Gunnedah Solar Farm EIS Submission

Orange Grove Sun Farm Pty Ltd (OGSF) hereby provides a submission to DPE in relation to the Gunnedah Solar Farm (Application No. 8658) EIS currently under public exhibition.

The submission raises OGSF's concerns relating to the Gunnedah Solar Farm Environmental Impact Statement (EIS) Appendix J Flood Report and Appendix I Traffic Impact Assessment.

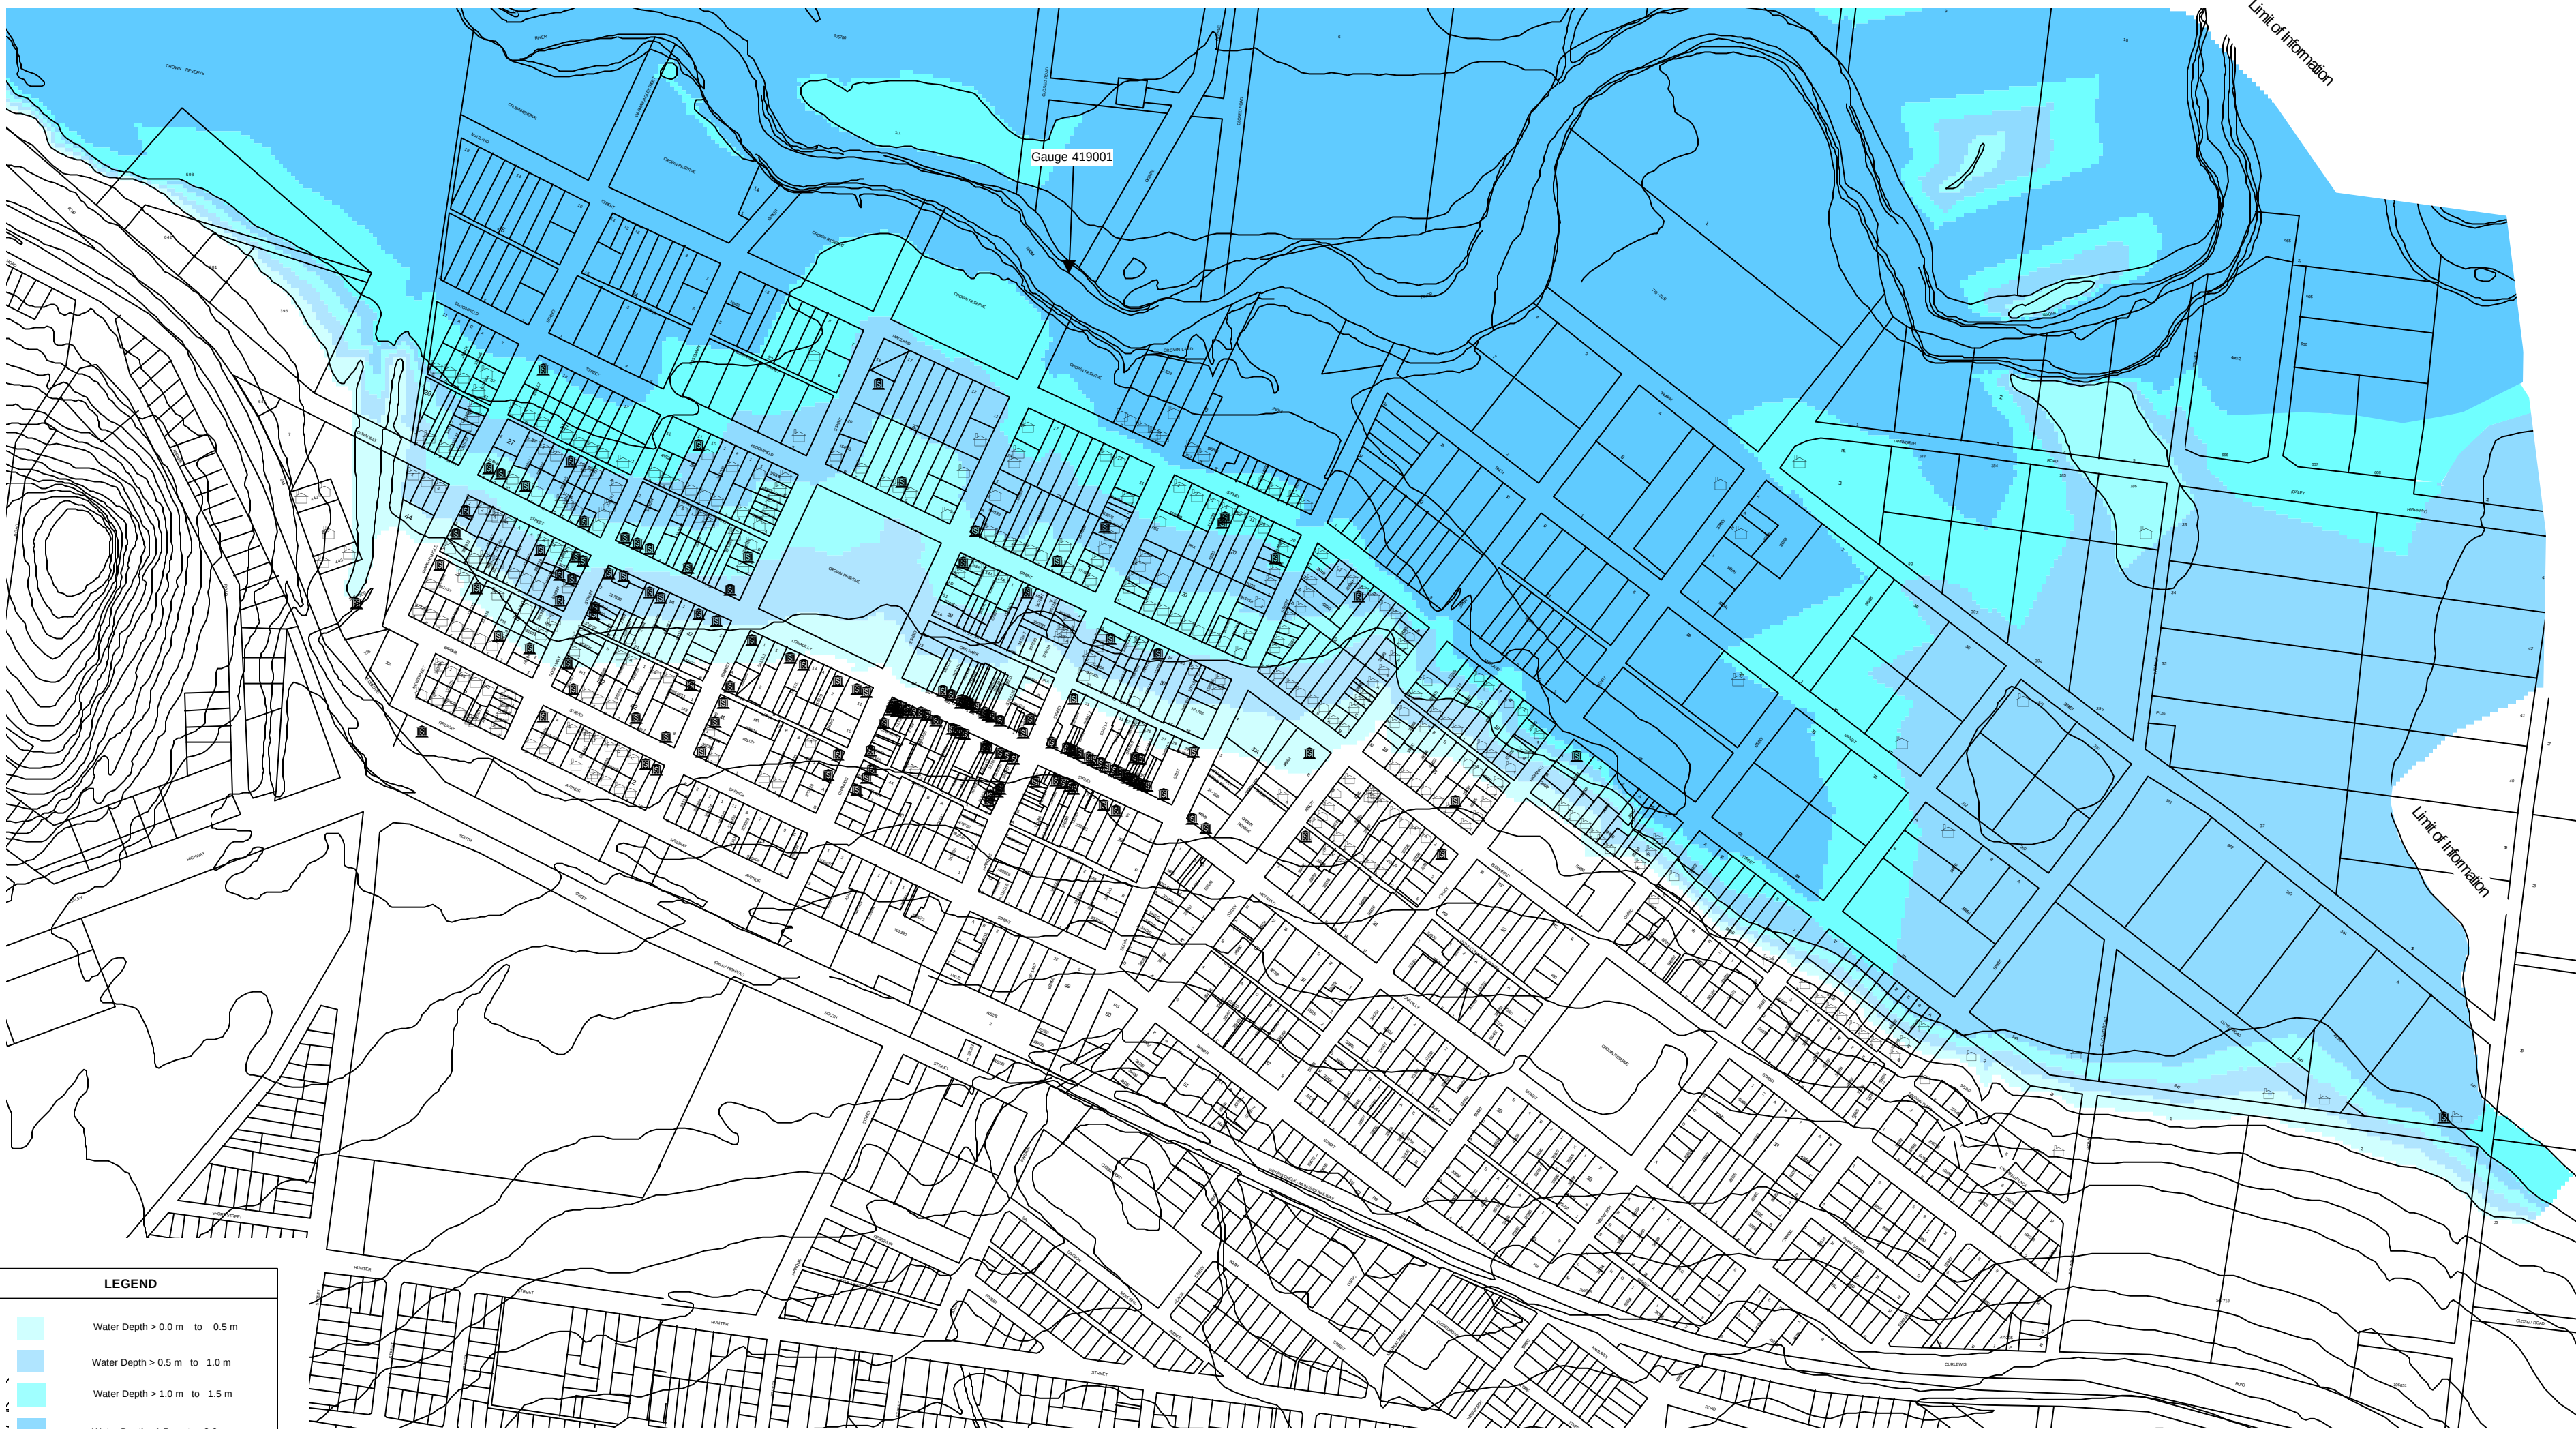
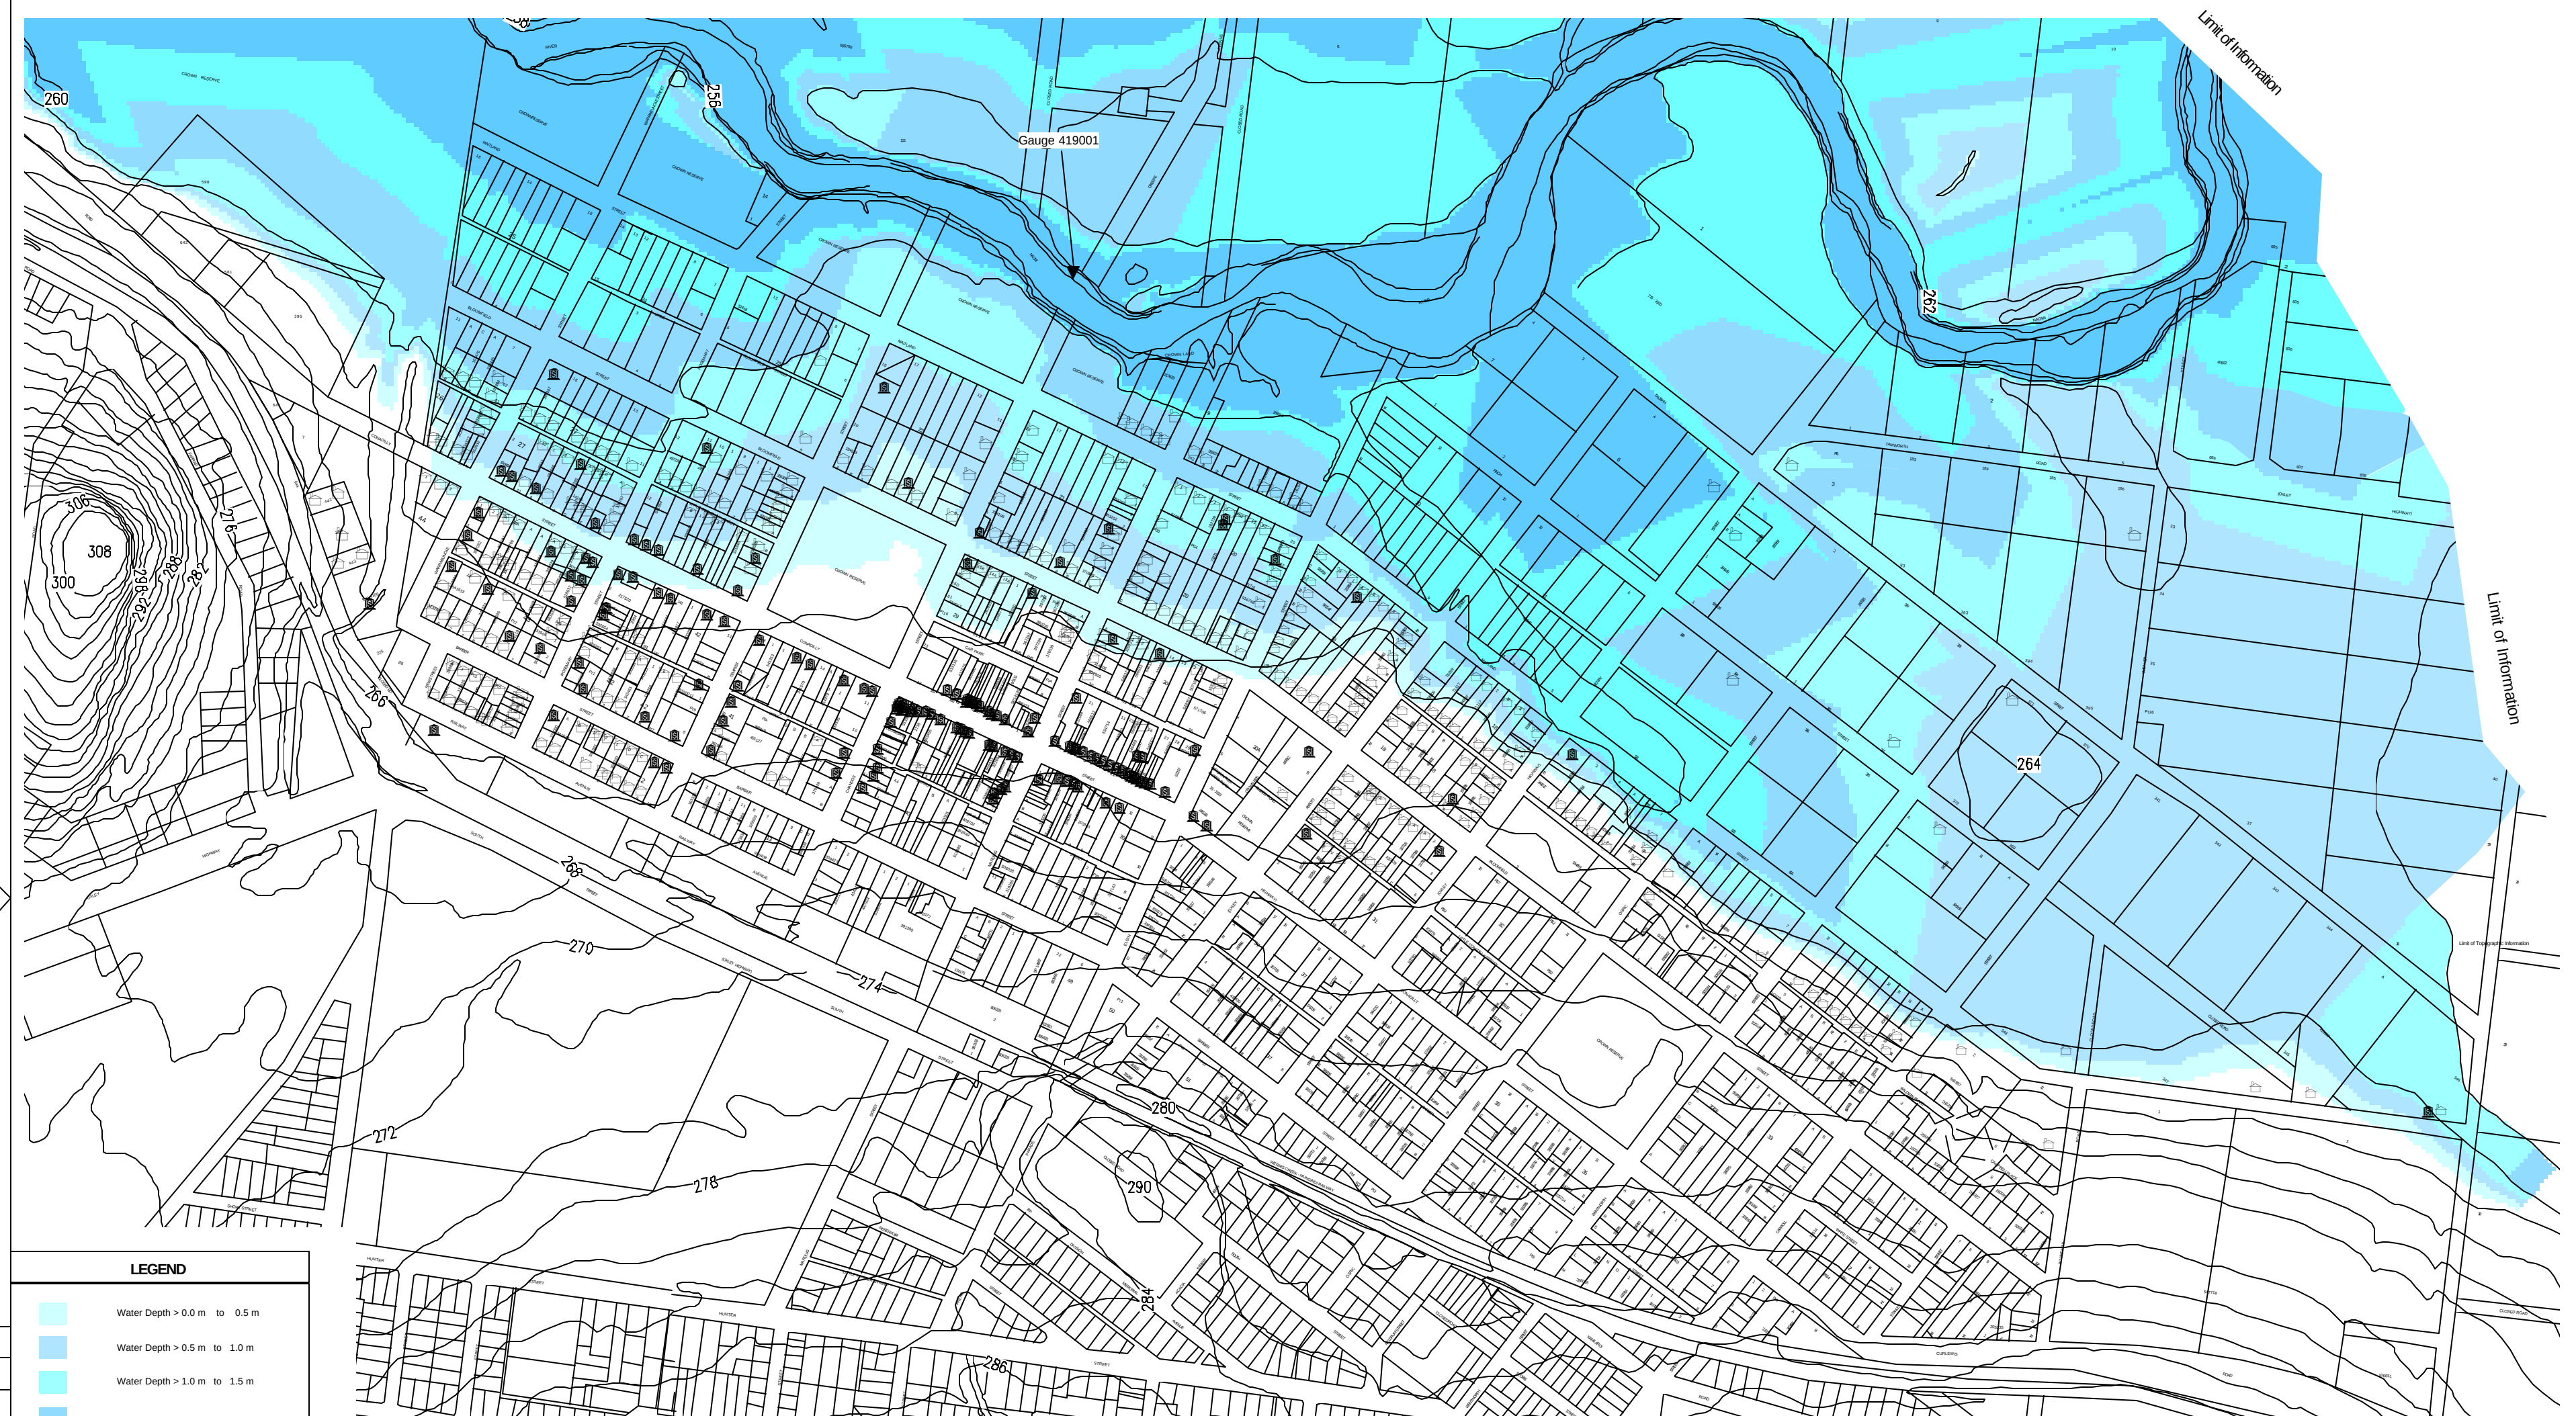
Further, Pitt & Sherry state in the EIS that information from the Gunnedah and Carroll Floodplain Management Plan 1999, SMEC study, updated 2014, was used in their flood modelling. The information includes inundation maps produced by SMEC for the town of Gunnedah and village of Carroll at 1% AEP and 5% AEP (*Attachment 3*). When the respective AEP inundation maps of both Pitt & Sherry and SMEC's are overlayed, there is variance of both the vertical and horizontal flood horizons within Gunnedah and Carroll.

It is recommended that Gunnedah Solar Farm undertake a reassessment of the modelling and flood assessment utilising topographical and spatial data of appropriate resolution, and that references the use of various hydrological and flood data in the modelling and assessment process.

Orange Grove Road, Gunnedah
1% AEP Flood Depth
Existing Scenario

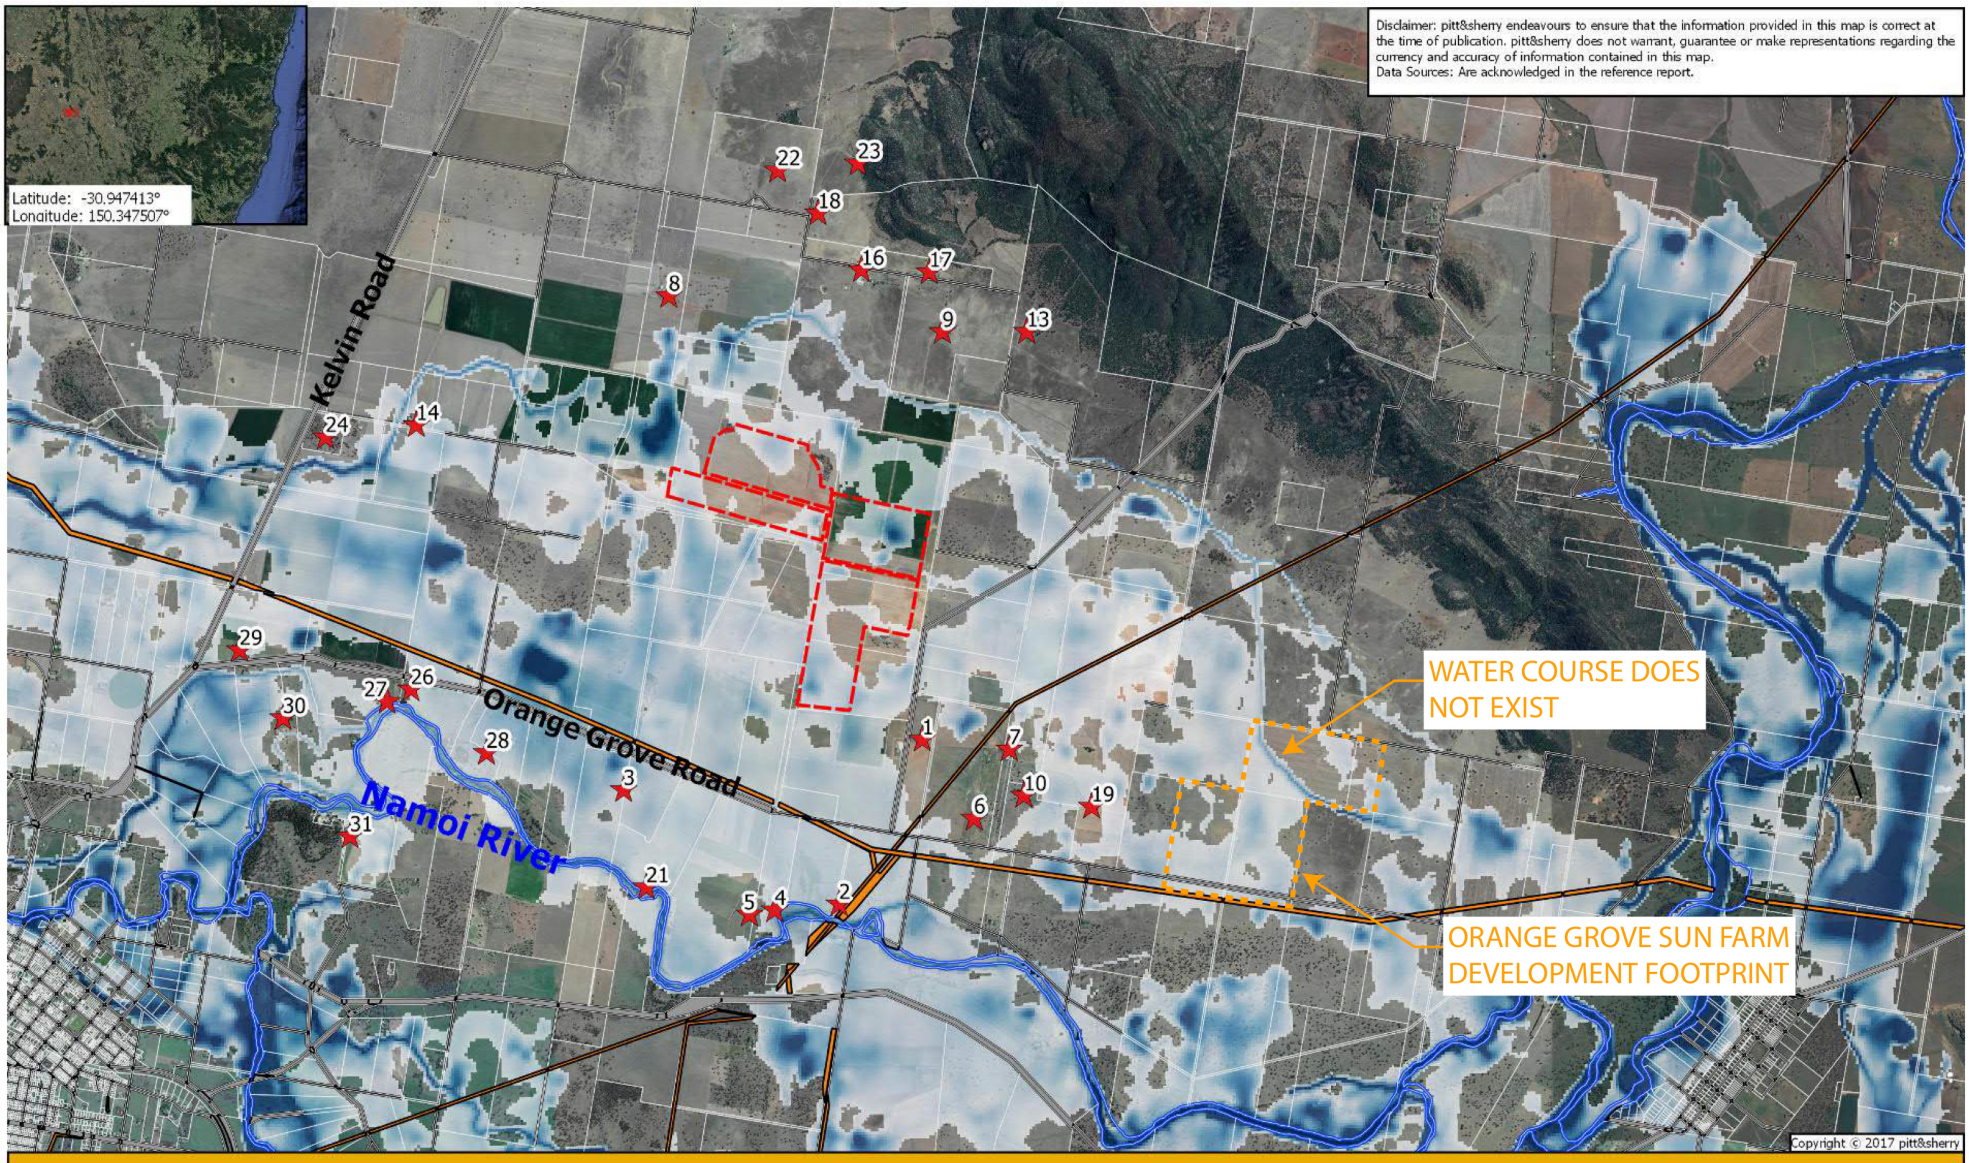
As a result of Pitt & Sherry's use of coarse data in the flood modelling for the Gunnedah Solar Farm, when the OGSF contour survey is compared to the Pitt & Sherry 1% AEP and 5% AEP *Flood Depth Existing Scenario* maps (*Attachment 2*) a misrepresentation of topographic elevations across the OGSF are present. For instance, there is a water course with flood depths in the order of 1.5 m depicted across the western side of the northern portion of the OGSF development footprint. The OGSF surveyed contours clearly show there is no channel present within that specific area, which actually has a relatively flat east to west gradient.
